From: Martyn White
Sent: 23 November 2018 10:58
To: Planning.Responses
Cc: Richard Castro-Parker
Subject: BR/244/18/PL

BR/244/18/PL

The application appears to be related to a change in the design of the proposed office building. It is assumed that the location of the building has not changed, nor has the previously approved signage.

Proposed Floor Plan & Elevations (1:100)

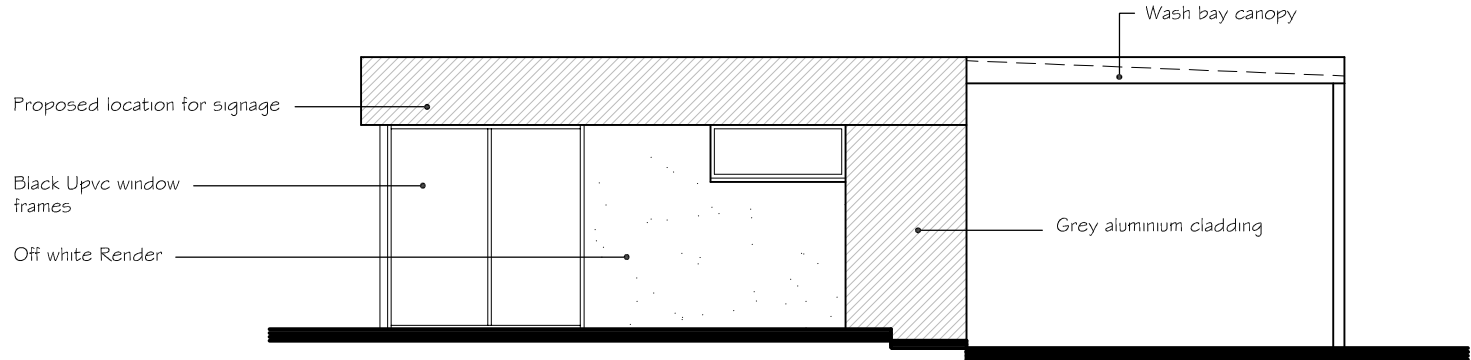
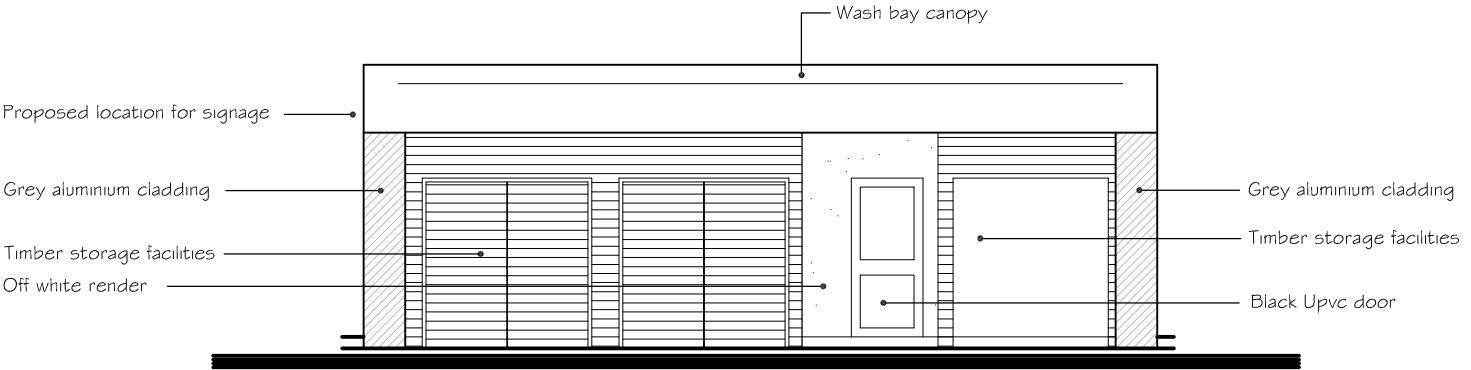
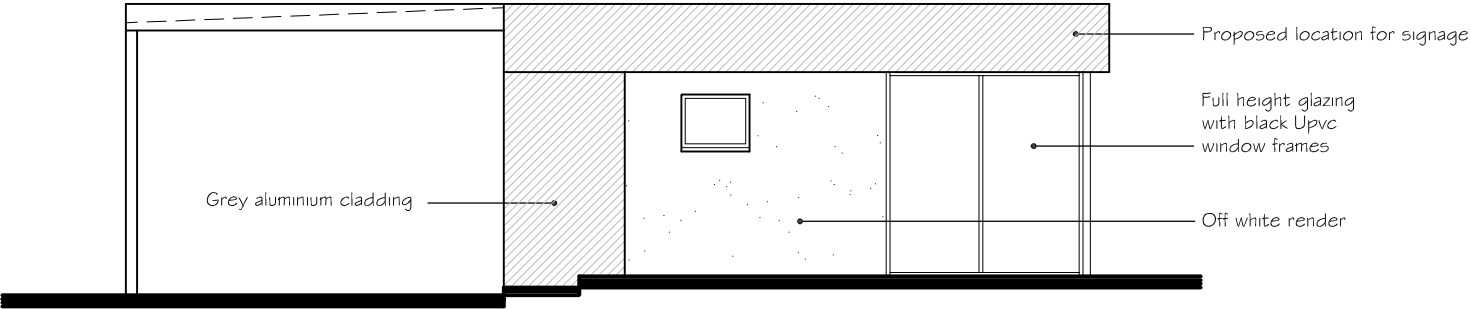
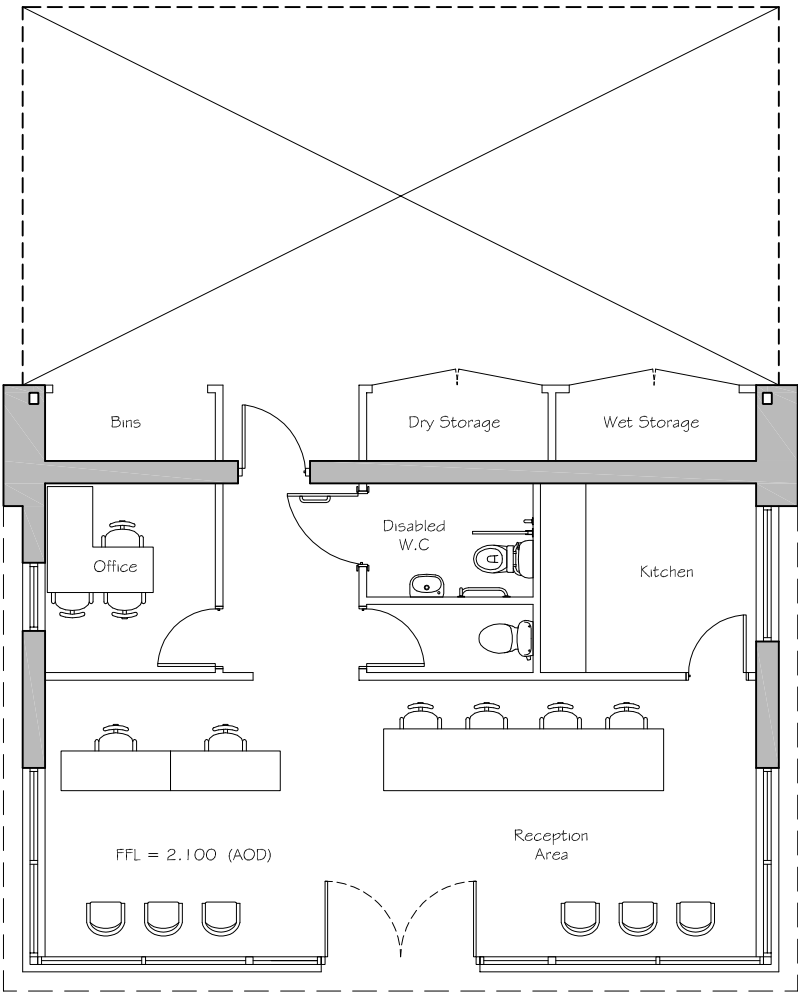
The revised design is considered to be acceptable, and capable of support.
